**APPLICANT'S RESPONSE TO THE ANGLIAN
WATER INFORMATION PROVIDED ON 16 AND
21 JUNE 2022**

PINS project reference: WS010005

PINS document reference: 15.2.6.2

Comments from the Applicant on the Information provided by Anglian Water on 16 and 21 June 2022

Drawing Ref
AU/KCW/06-22/23193

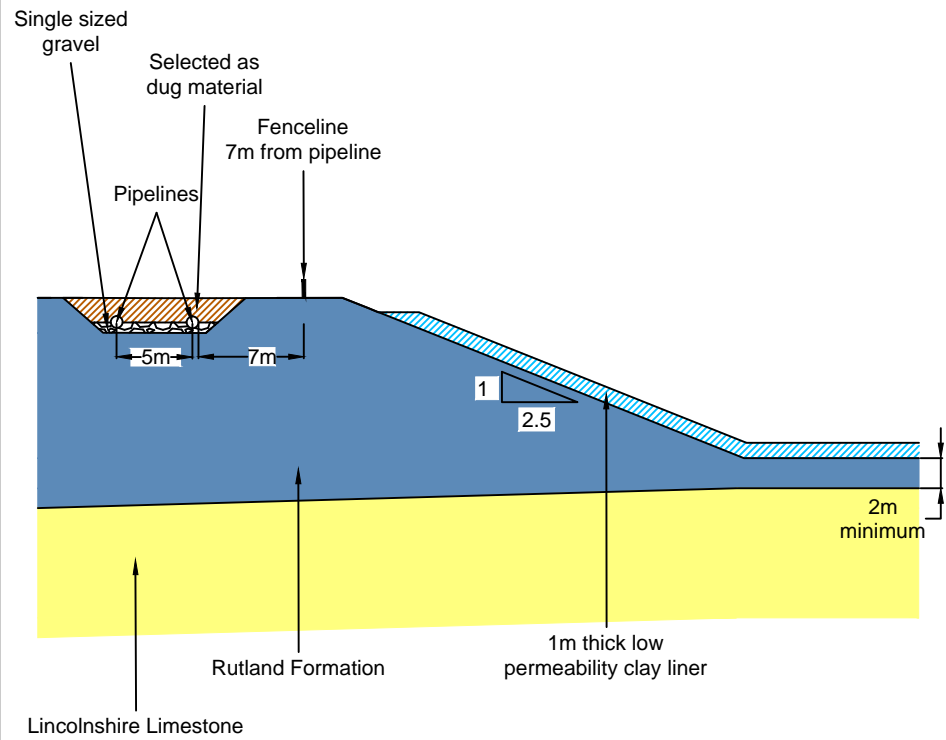
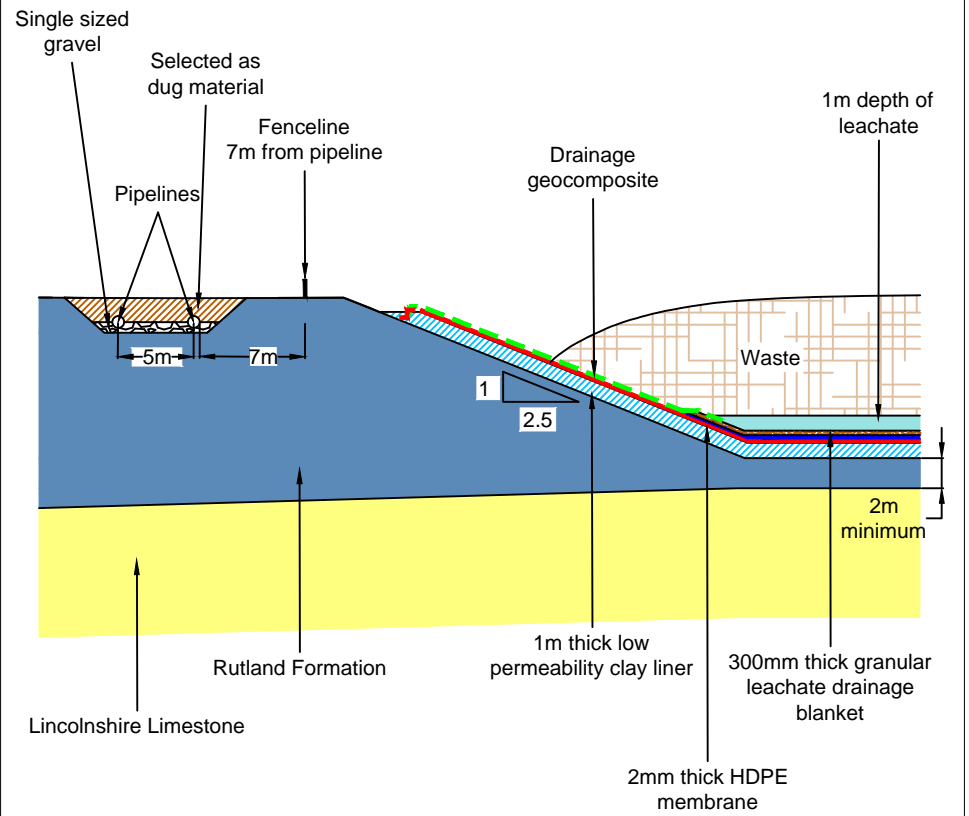
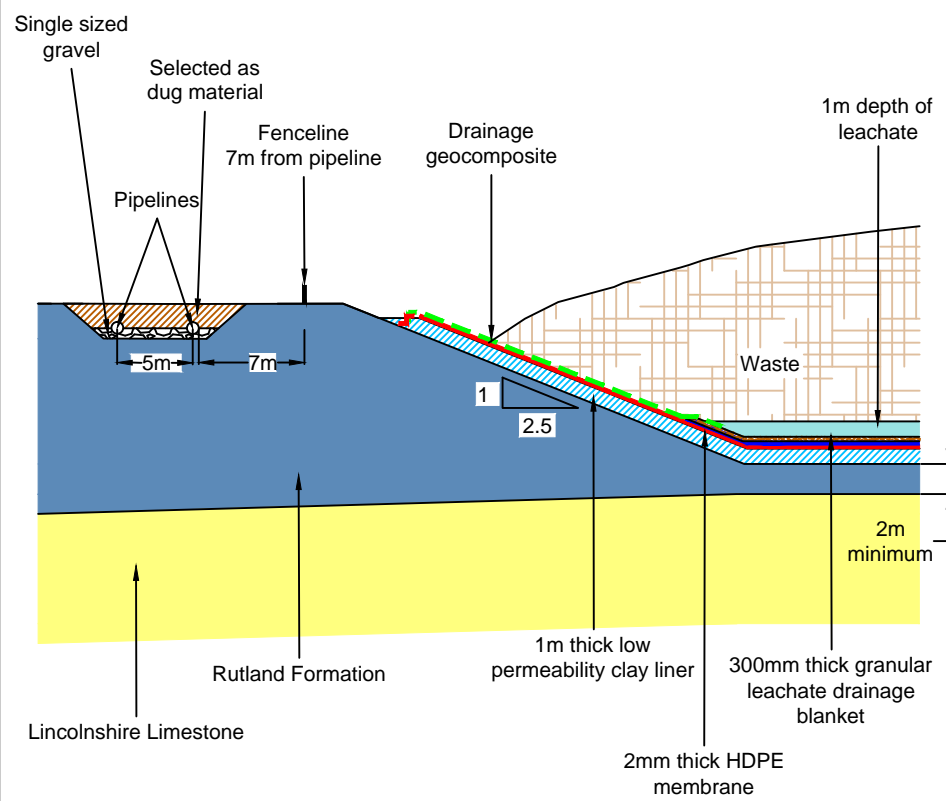
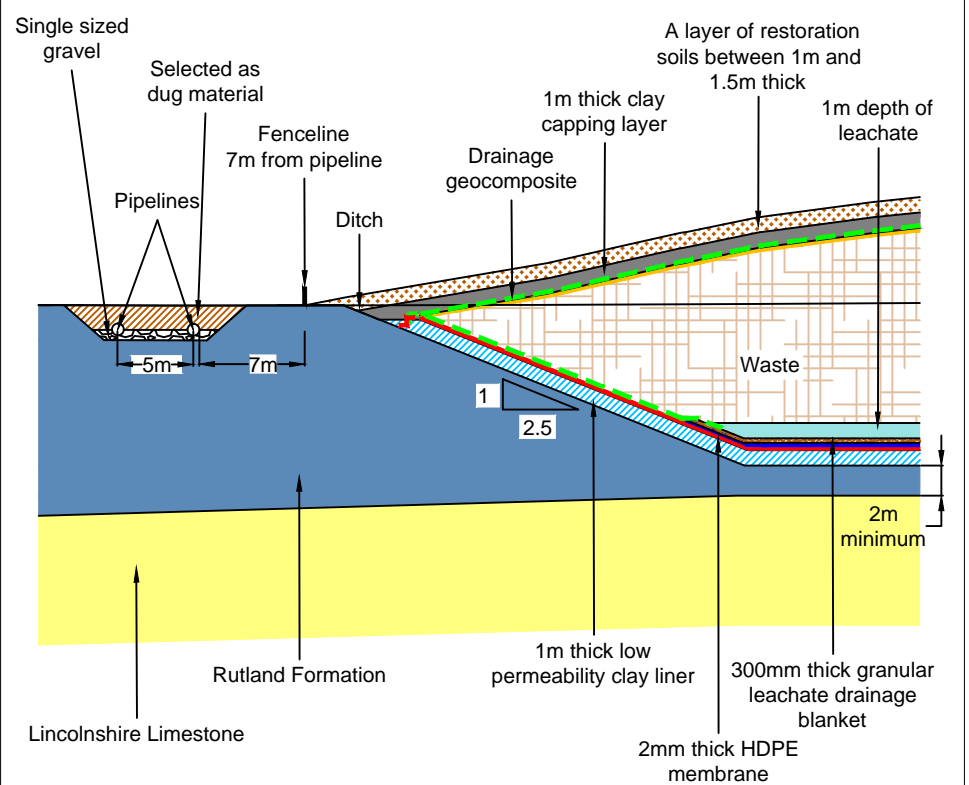
Information provided by Anglian Water on 16 June 2022	Summary comments from the Applicant	Actions arising
<p>attended to a leak on the pipeline immediately adjacent to the Western boundary where it enters the proposed development.</p> <p>Our concern remains the proposed easement, its long-term exposure, lack of monitoring and potential to resist extreme weather events of cold weather or drought periods which increases our risk significantly. In addition, the phased delivery of excavation and fill, including crossing of our pipelines to achieve this also contribute to undefined loading and therefore risk.</p> <p>Any resulting failure from the impact of that described places significant risk of customer supply, reputation and cost to Anglian Water. We remind you that this is not a small service easily re-zoned but a major trunk main providing water to the city of Peterborough hence our view to remove this from the development area, as per the previous pipeline relocation.</p>	<p>carry out repairs. The risk of significant leaks can be reduced further by the maintenance of the existing cathodic protection and by monitoring for leaks as suggested by the Applicant.</p> <p>The issues of “long term exposure”, “extreme weather events of cold and drought” are not influenced by the development. There will not be “undefined loading” as a result of the development as the impacts of excavation and fill and crossing have been defined. Nevertheless, the consequences of failure have also been assessed.</p>

<p>Agreement is needed on what activities by Augean are acceptable in the standoff area.</p> <p>Specify the easement width assessed? AW has made its minimum position clear.</p>	<p>The intention of this information request is to obtain details from Anglian Water regarding what types of landscape planting, such as hedges and trees, are acceptable within specified distances of the water pipes. These details will be agreed with Anglian Water for the standoff area prior to finalisation of the standoff details.</p>	<p>No change needed to the submitted risk assessments and non material change request.</p>
<p><i>Anglian are requested to confirm whether</i> the pipes deliver treated water directly to supply or whether the water is directed to a blending/treatment facility before entering supply. The pipes deliver clean and wholesome drinking water into to the distribution system for consumption – no further treatment is provided.</p>	<p>This information is helpful confirmation but does not affect the approach to or conclusions of any of the risk assessments presented with the request for a non material change.</p>	<p>No change needed to the submitted risk assessments and non material change request.</p>

Route 3

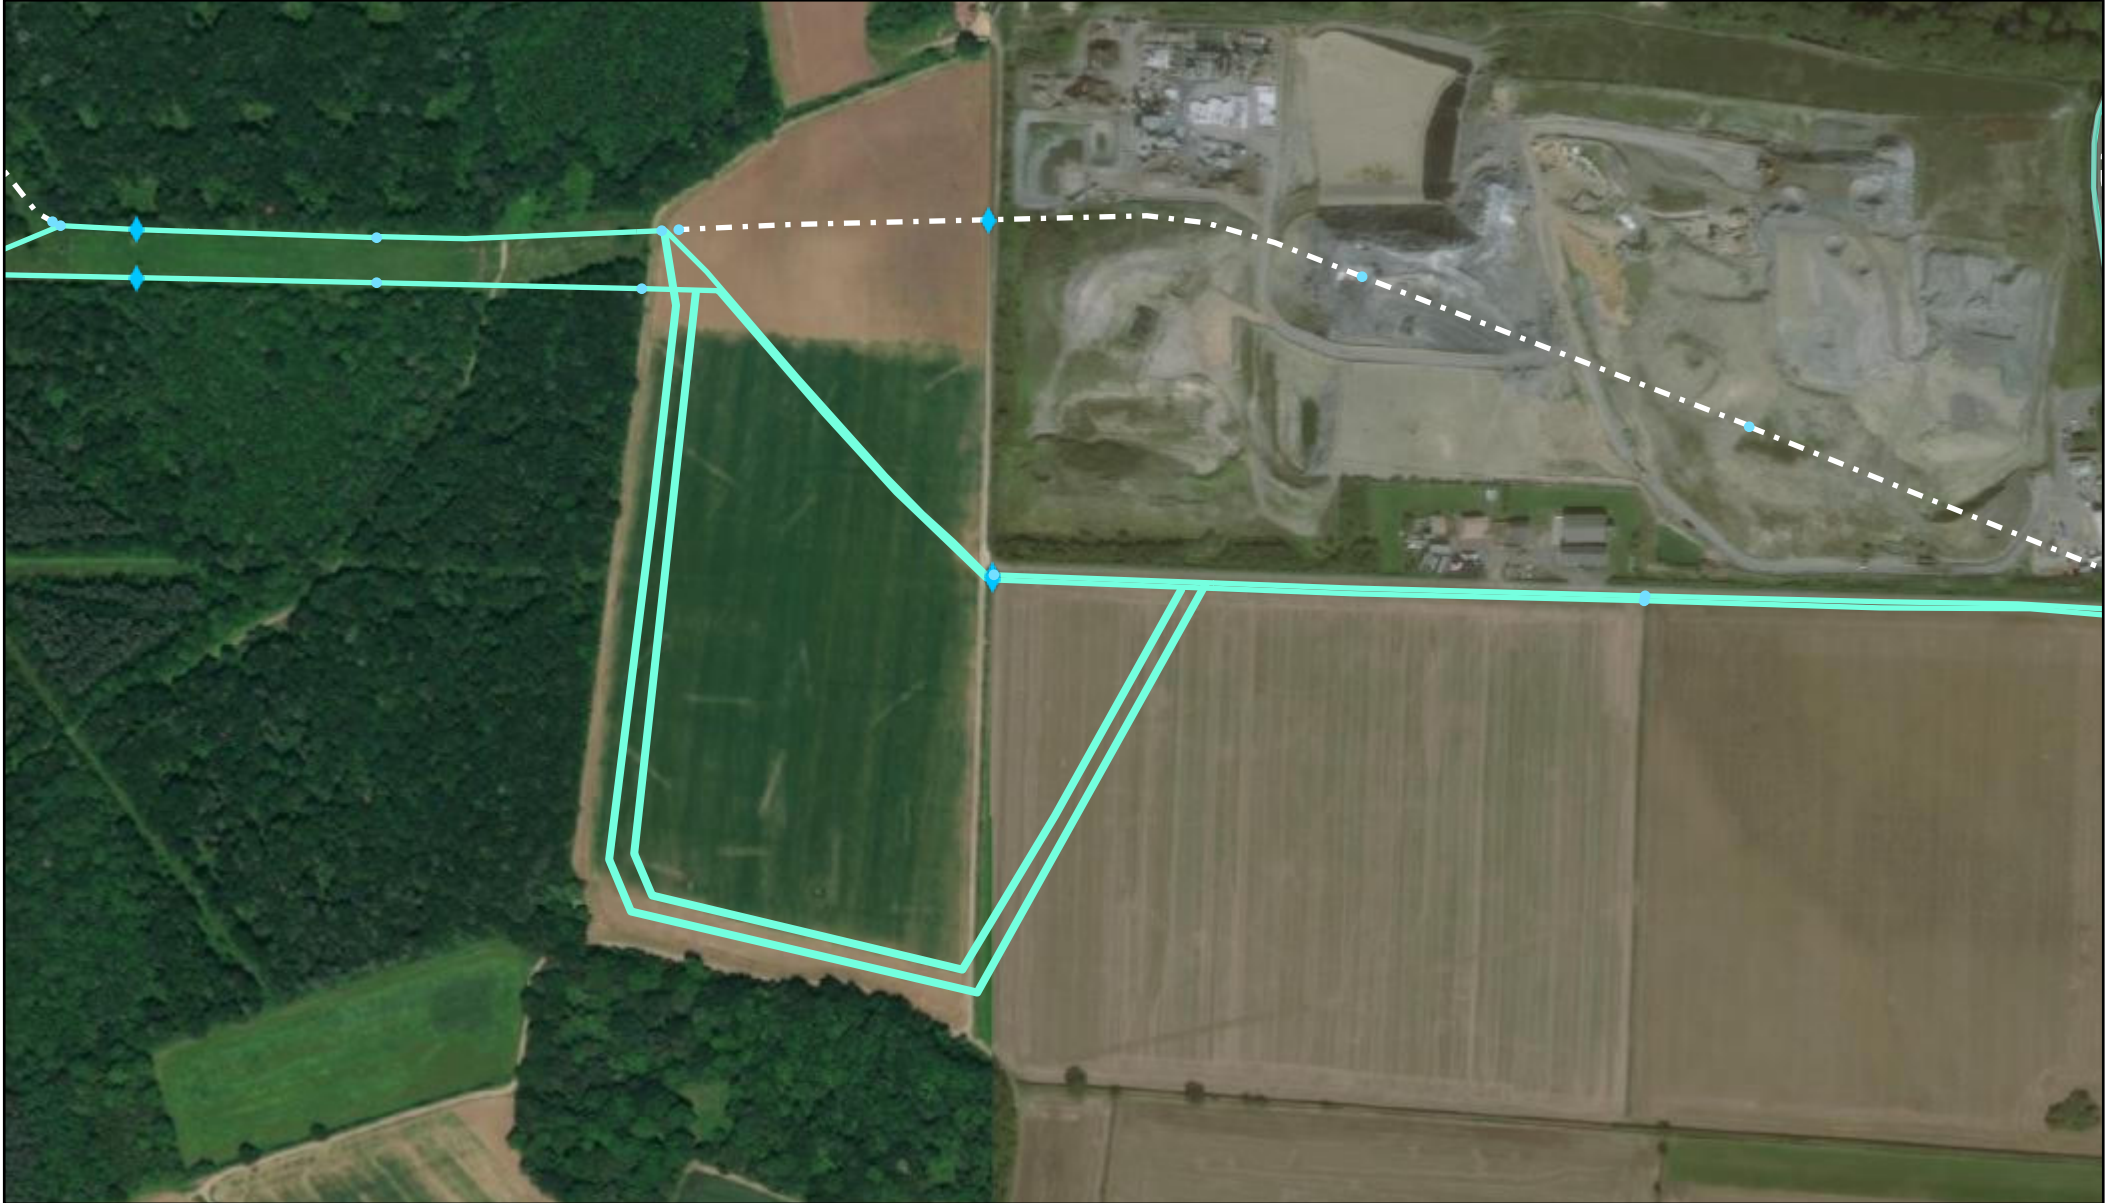
Information provided by Anglian Water on 16 June 2022	Summary comments from the Applicant	Actions arising
Provision of "as built" information	The information provided comprises a GIS plan showing the locations of the pipes together with attribute tables listing some construction details. The Applicant is seeking clarification from Anglian Water regarding the interpretation of the legend with the attribute tables so that the information is understood.	The initial review suggests that there are no changes needed to the submitted risk assessments and non material change request.
